**The Hinkley Point C (Nuclear Generating Station)
(Amendment) Order 2021**

Made - - - - *16th December 2021*

This Order follows an application under paragraph 2 of Schedule 6 to the Act for a non-material change to allow for changes to the site layout and design of buildings and structures within the

Site layout Plan (Operational)
Regulation 5(2)(o)

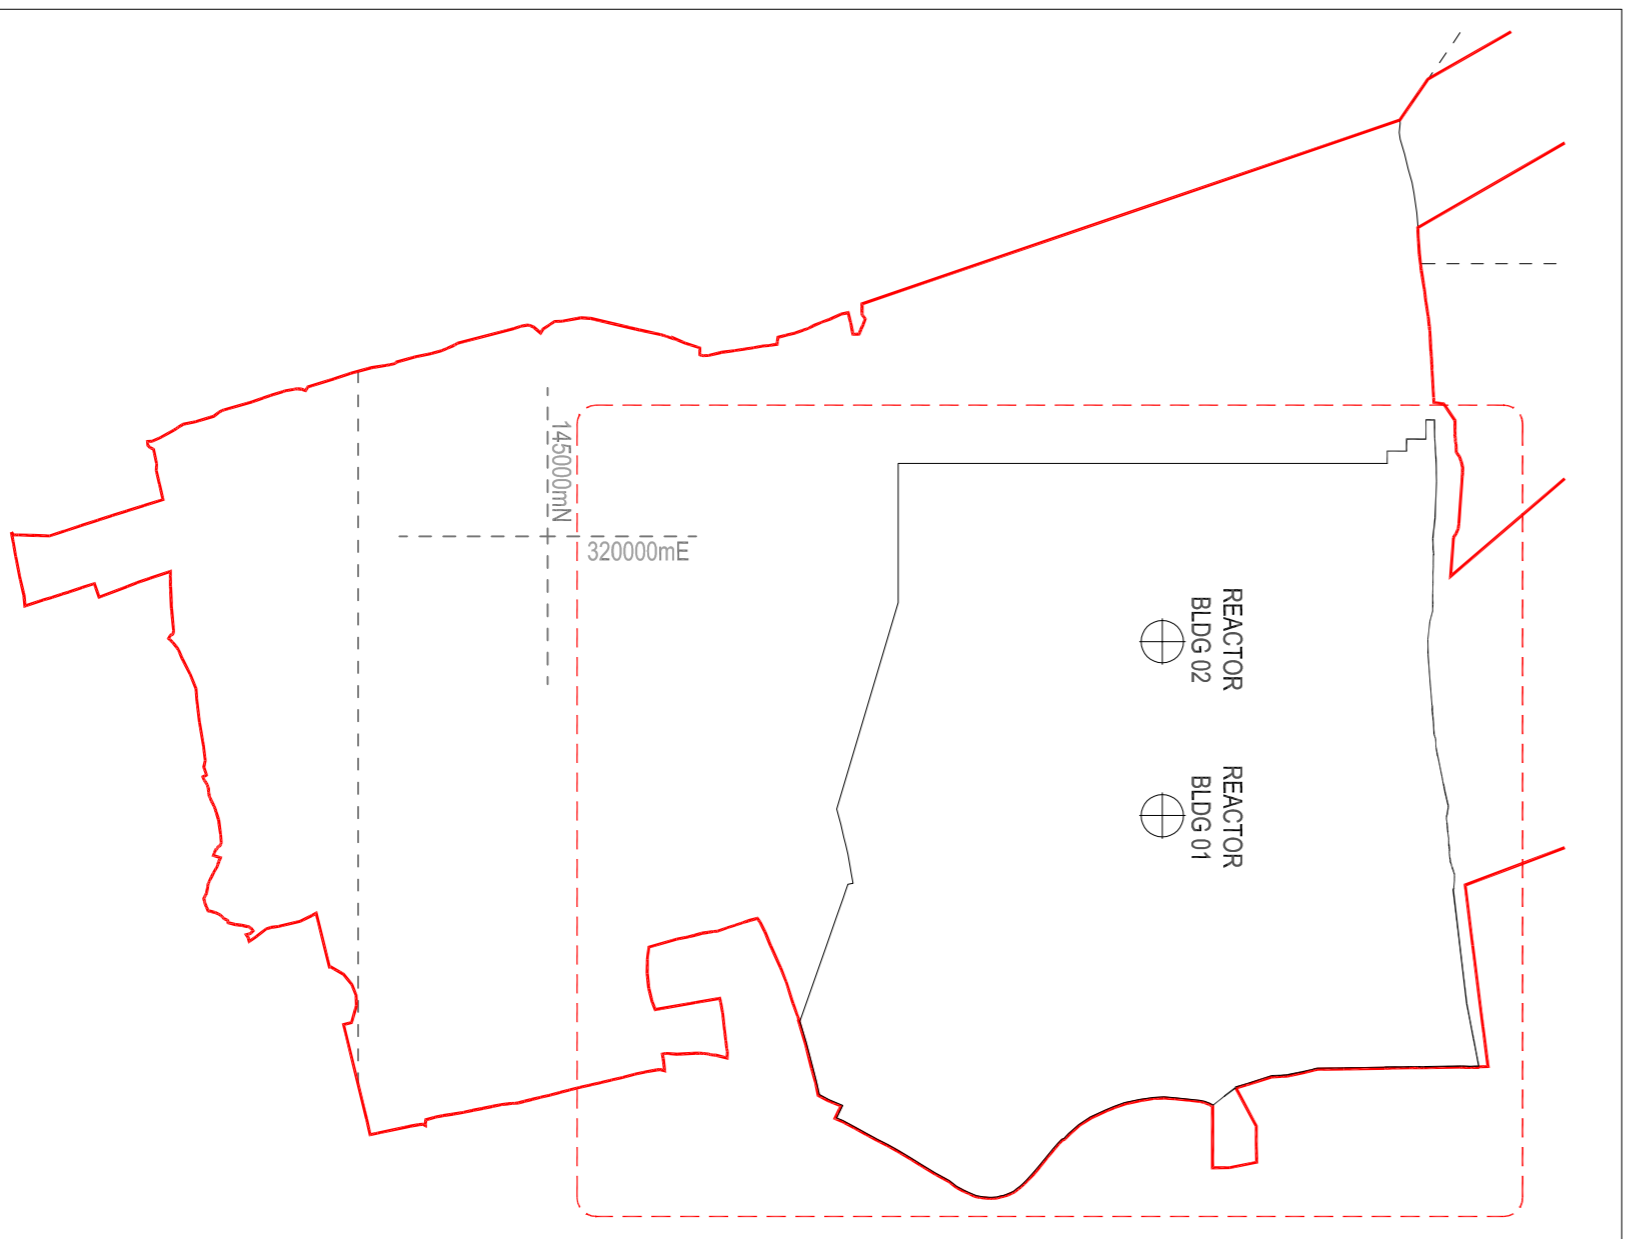
(2) For the approved plans listed in paragraph (3) substitute the approved plans listed in Schedule 1 to this Order.

- (b) in the definition of “HPC operational car park”, for “(no. 62)” substitute “(no. 67)”.
- (3) In paragraph 2, in sub-paragraph (2) of requirement PW3 for “Rev 03” substitute “Rev 04”.
- (4) In paragraph 4—
 - (a) in sub-paragraph (2) of requirement MS19 for “Rev 03” substitute “Rev 04”;
 - (b) in sub-paragraph (2) of requirement MS21 for “Rev 03” substitute “Rev 04”;
 - (c) in sub-paragraph (1)(b) of requirement MS25 omit “, including siting of the helipad”;
 - (d) in the heading of requirement MS34 for “Helipad Use” substitute “Helicopter Flights”;
 - (e) in sub-paragraph (1) of requirement MS34 for “using the HPC helipad” substitute “to and from the HPC development site”;
 - (f) in sub-paragraph (2) of requirement MS34 for “HPC helipad” substitute “HPC development site”; and
 - (g) in requirement MS35 for “HPC helipad” substitute “HPC development site”.

DRAWING TITLE
Hinkley Point C Development Site
Emergency Response Energy Centre (HDU)
Roof Plan and Elevations
Regulation 5(2)(o)

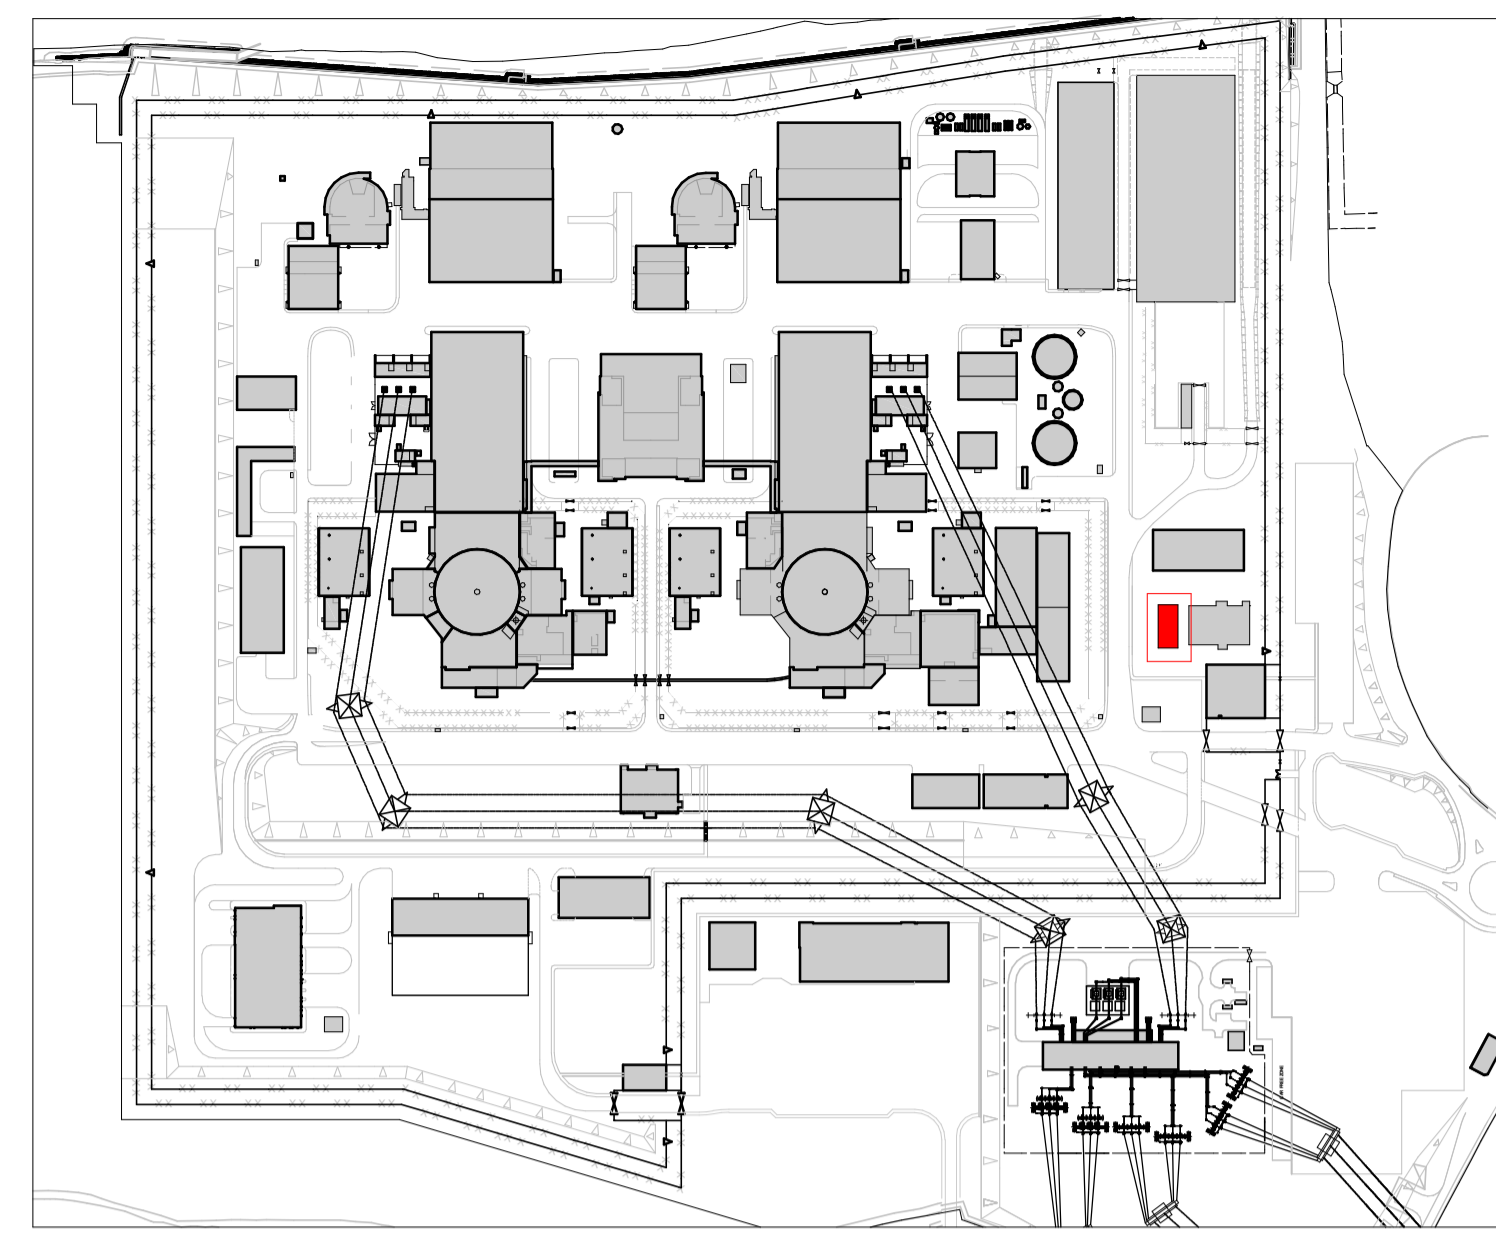
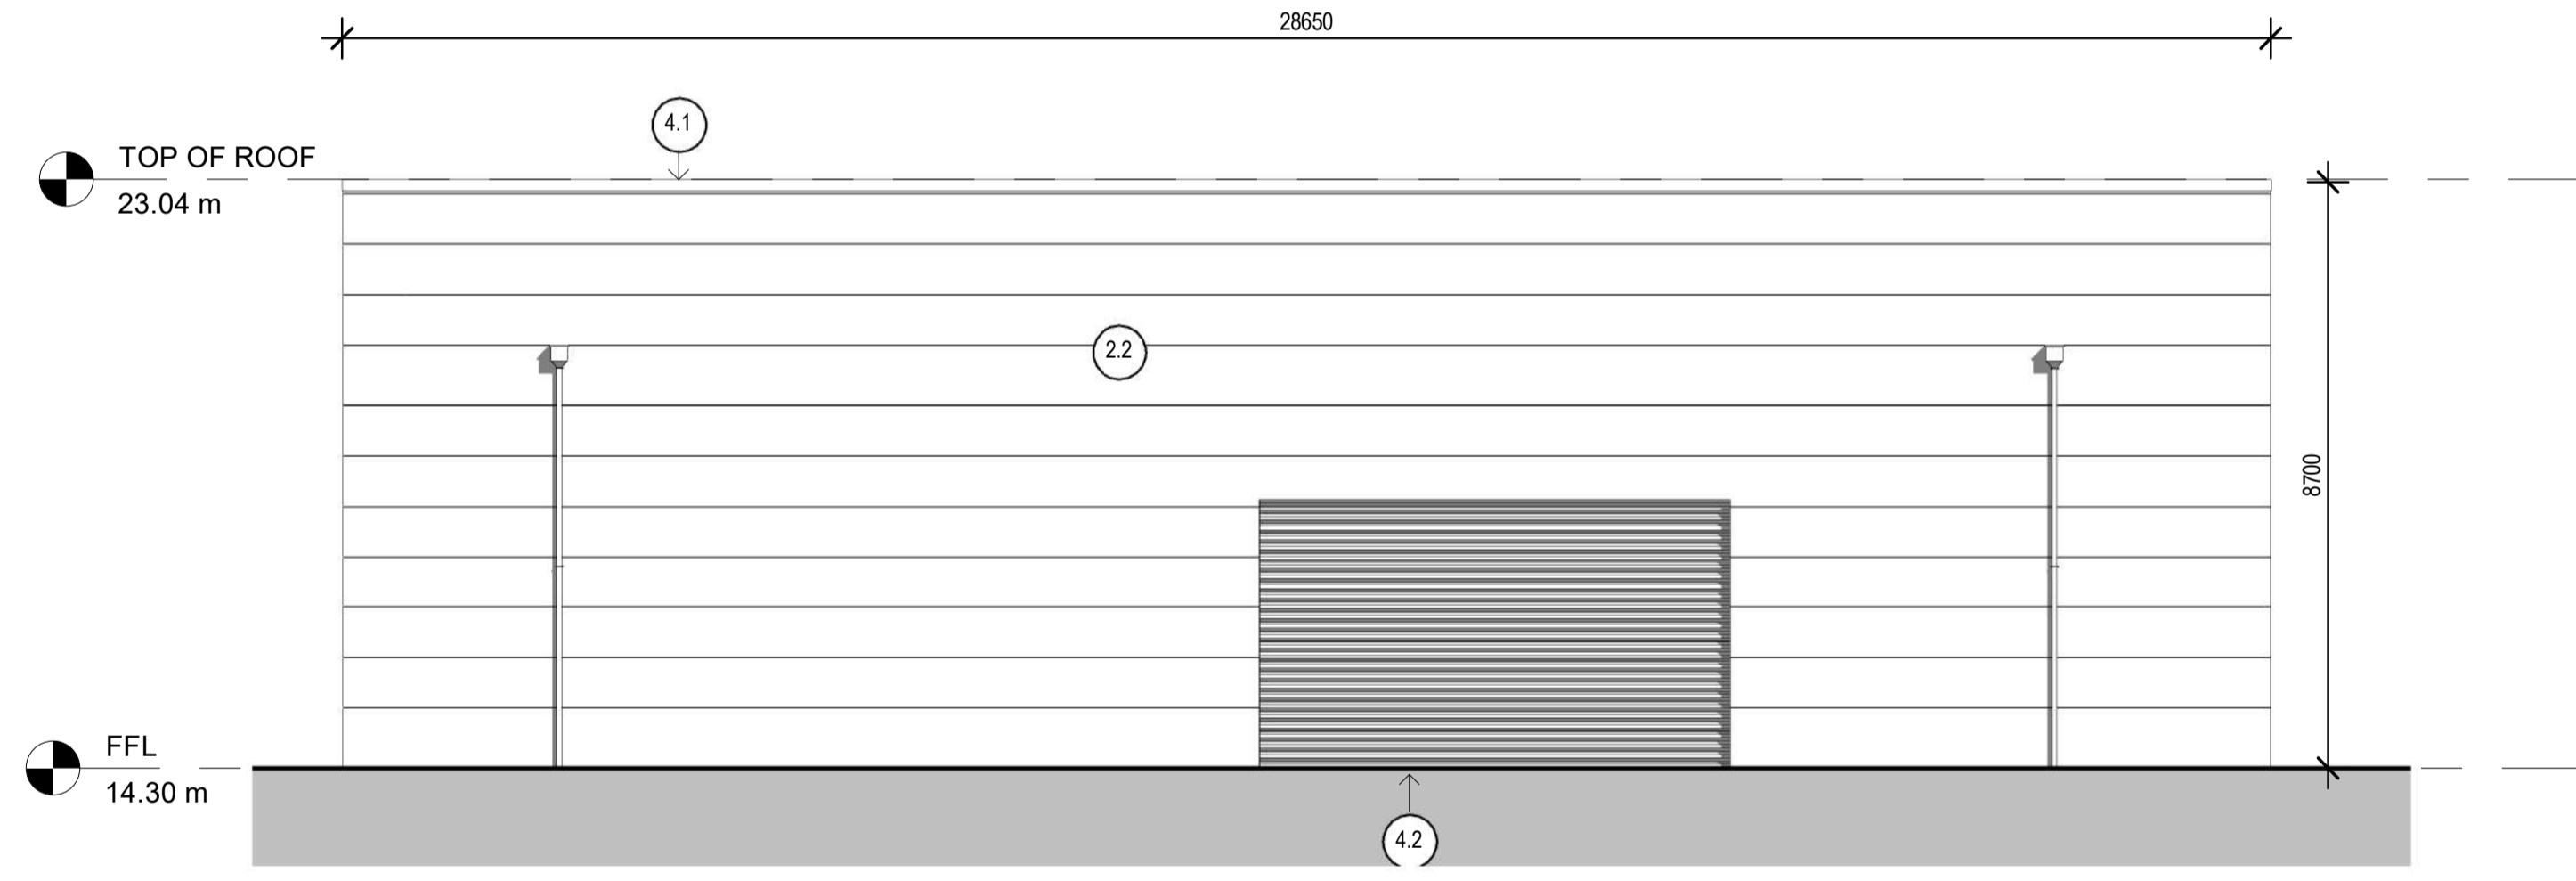
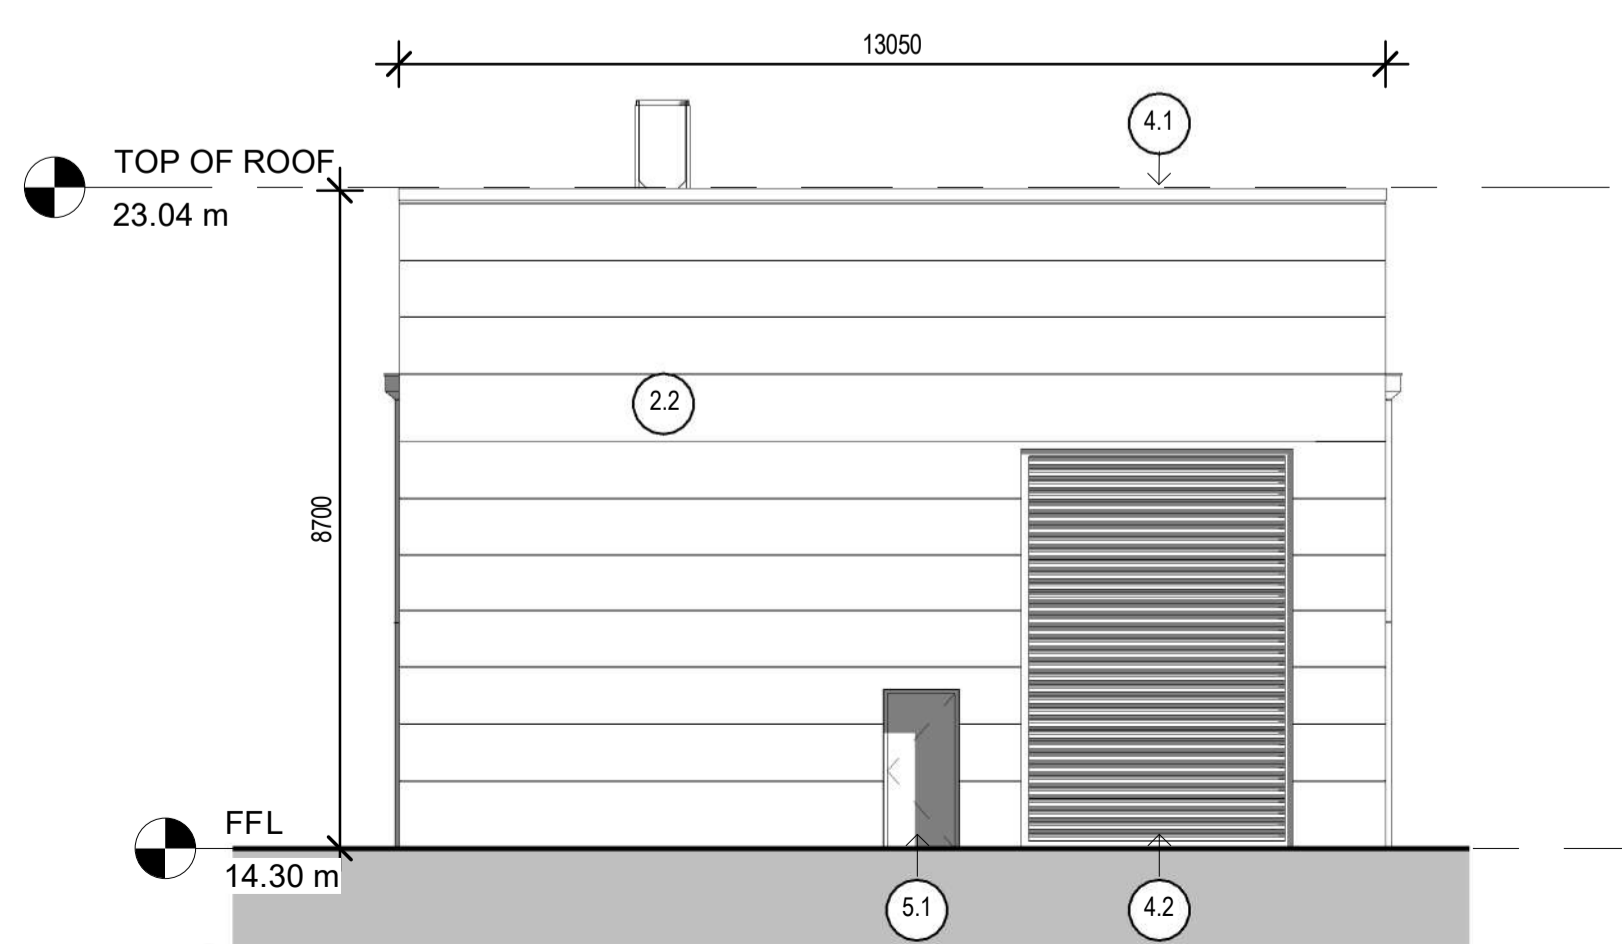
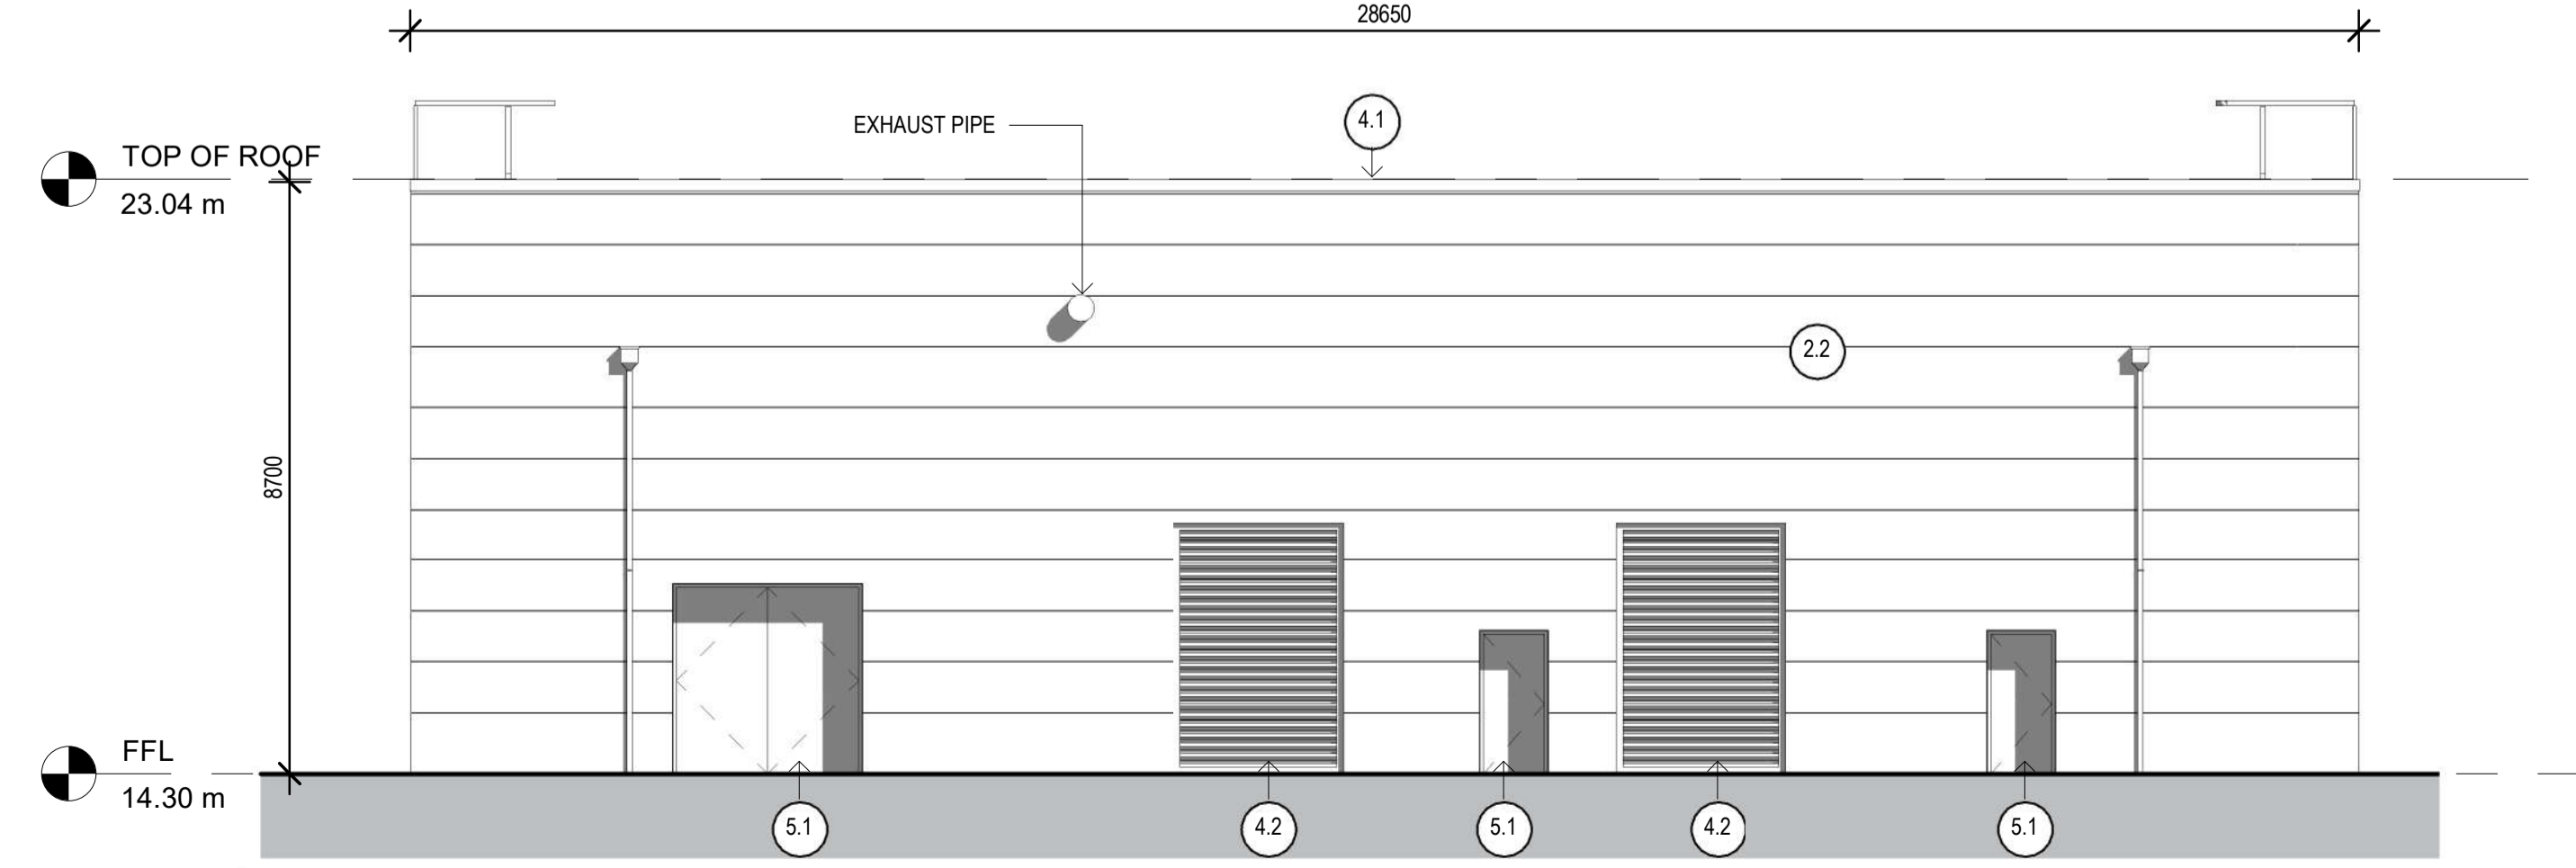
(6) After the approved plans listed under the heading “Services Ventilation Building” insert the lists of approved plans under the new headings “Off Site Delivery Checkpoint”, “Emergency Response Centre” and “Emergency Response Energy Centre” as set out in Schedule 2 to this Order.
